File No: NTH19/00212/04

Your Ref: SSD-8530563

**RE: Major Project (SSD 8530563) Gunnedah Waste Facility – Review of EIS  
Lots 1 & 2 DP 1226992 - 16 Torrens Road Gunnedah**

**Transport for NSW Response**

Figure 6.4: B-double Routes – Gunnedah Region

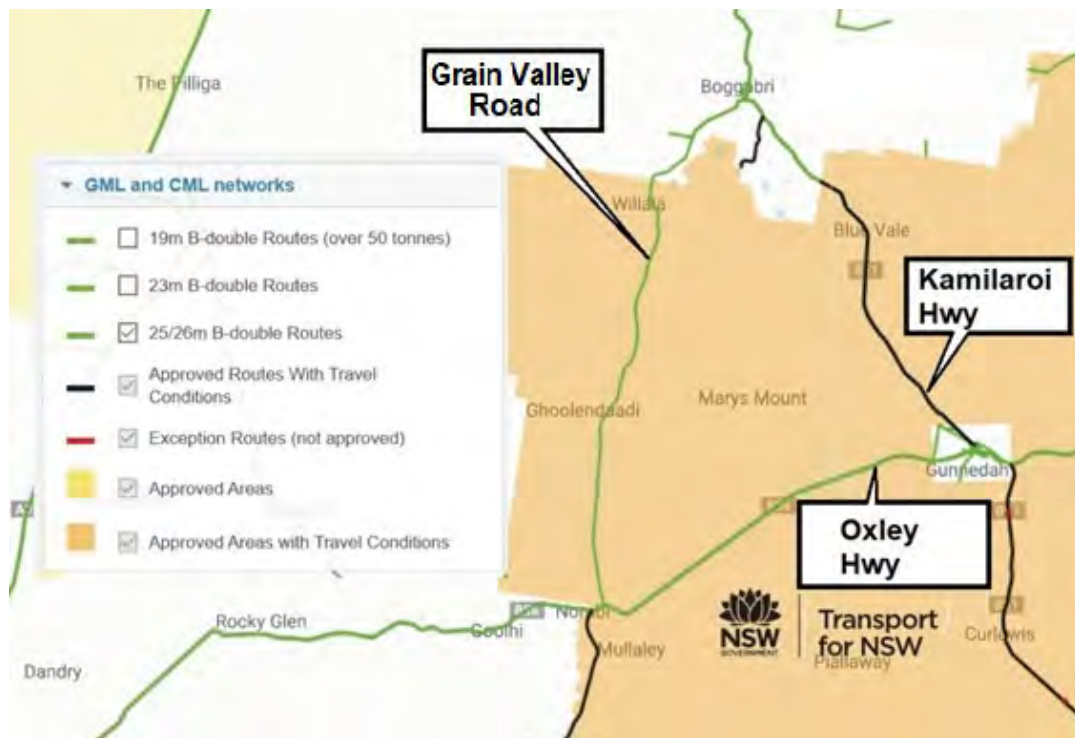
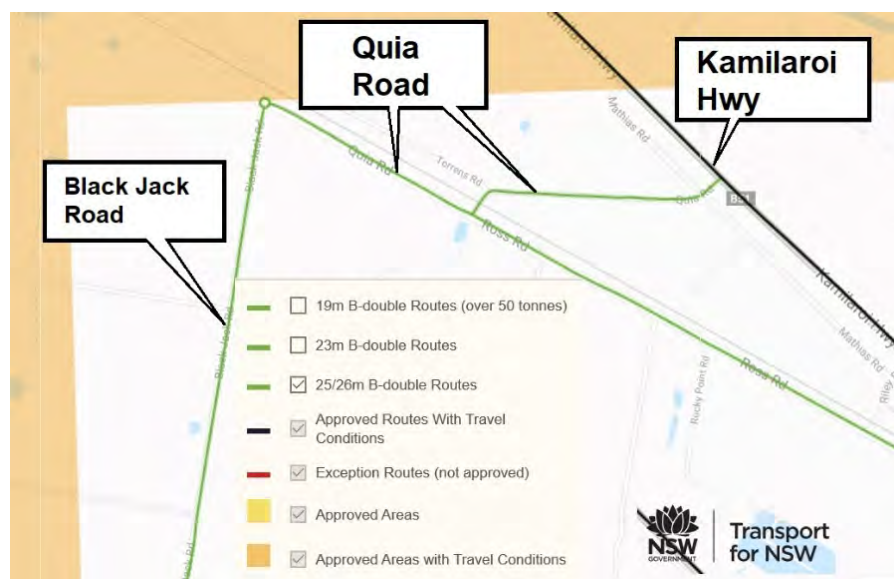
2. Site Access from Torrens Road (the main site access) only allows general access vehicles. TfNSW's road access team identifies that Torrens Road is not on either the PBS 2A or the 25/26 m RAV B-double network.

In order for the proponent to legally operate the larger vehicles, a permit from the Heavy Vehicle Regulator (NHVR) will be required. The proponent will need to work and consult with Gunnedah Shire Council to provide their consent for heavy vehicle access on this road.

Figure 8.8: AustRoads Warrant showing turn volumes at Quia Rd & Torrens Rd intersection

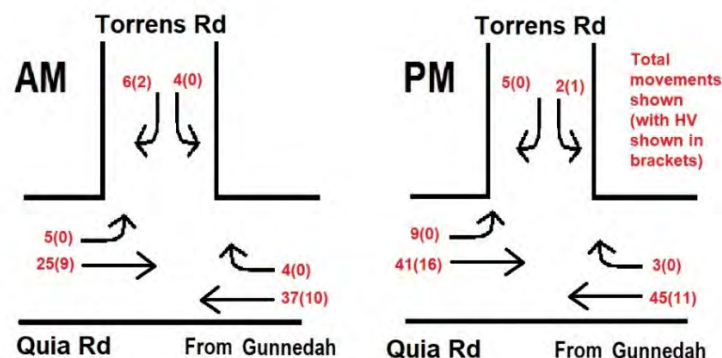
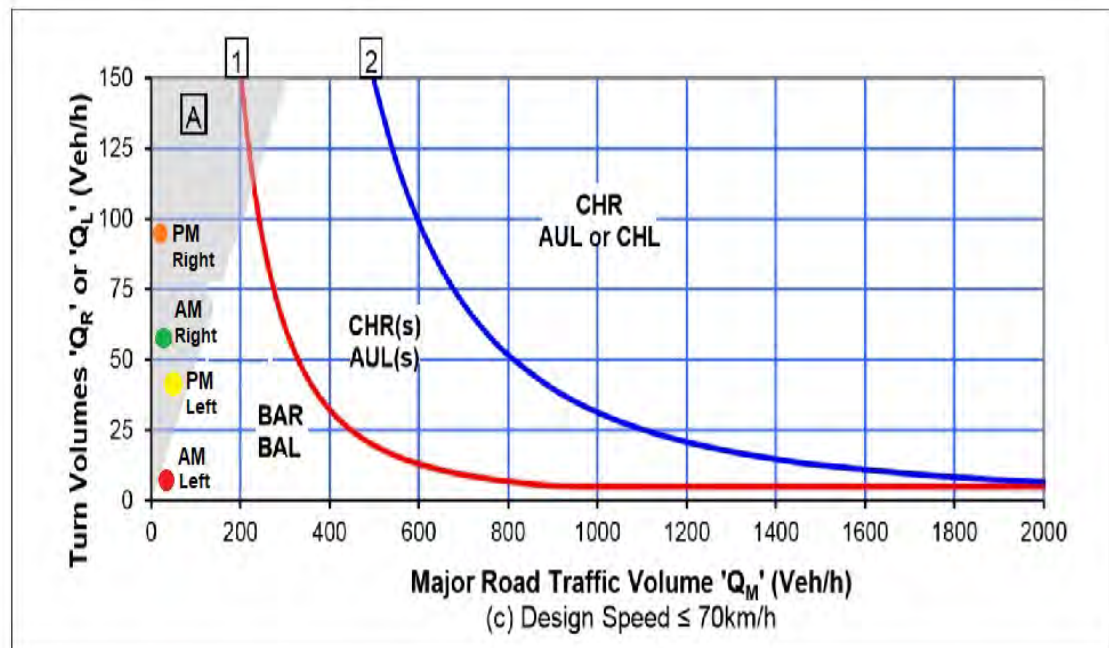
5. The TIA claims that a through vehicle can pass a right-turning vehicle at the intersection of Quia and Torrens Rd. The widths are not quantified and it appears that a BAR does not exist. It might be the case for 2 light vehicles (LV) but not for articulated heavy vehicles (HV) with greater swept paths. The existing guardrail would not comply with BAL requirements. This should be further investigated and addressed by provision of swept paths to demonstrate the safety impacts for increased turning traffic.

Figure 11.5: Future MEX depot layout showing location of waste facility, access locations, carparking and turn movements of articulated vehicles through the site.

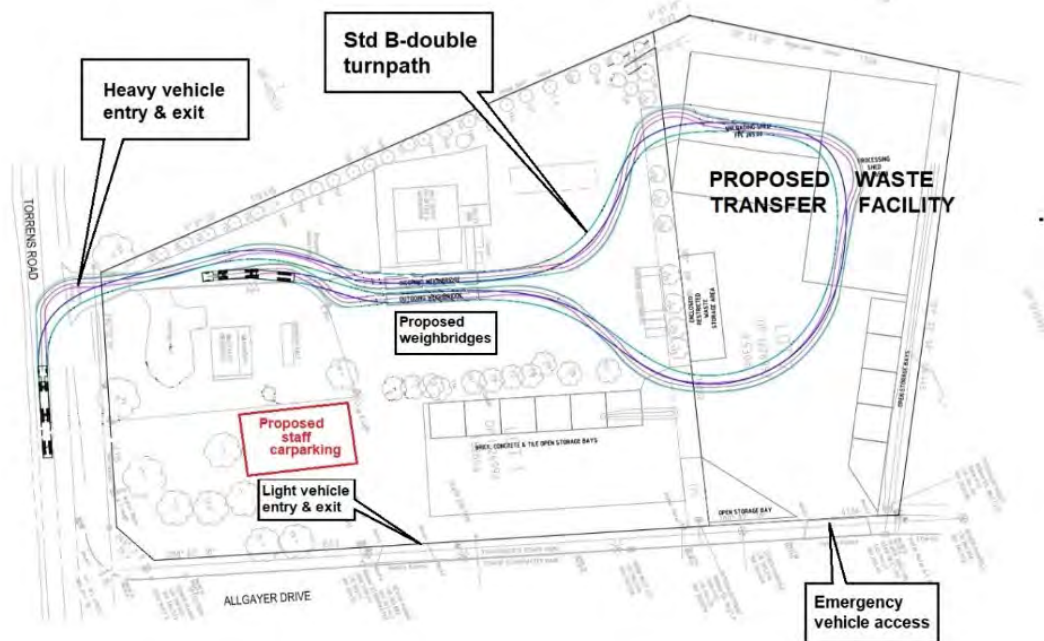
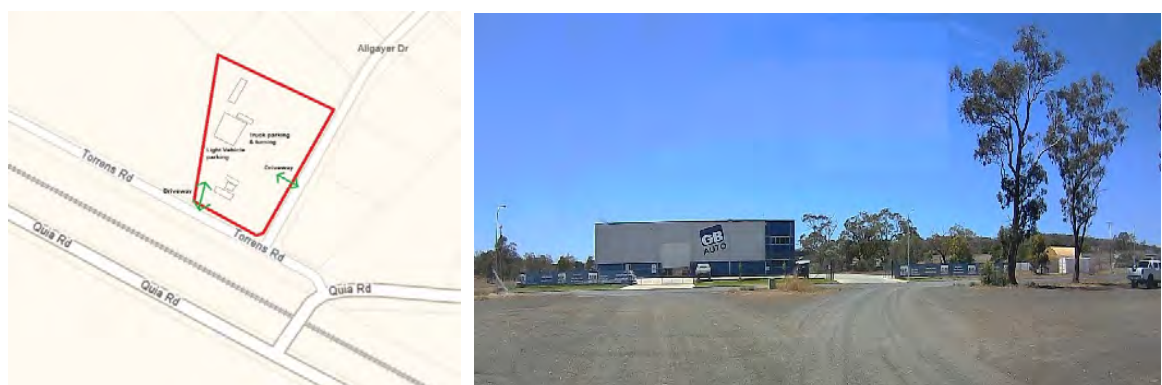
6. MEX Depot access details were not quantified in the TIA and therefore it is no possible to check if they meet AS2890 requirements. Swept paths appear to indicate that a B-Double cannot exit onto the correct side of the road. This should be reviewed.
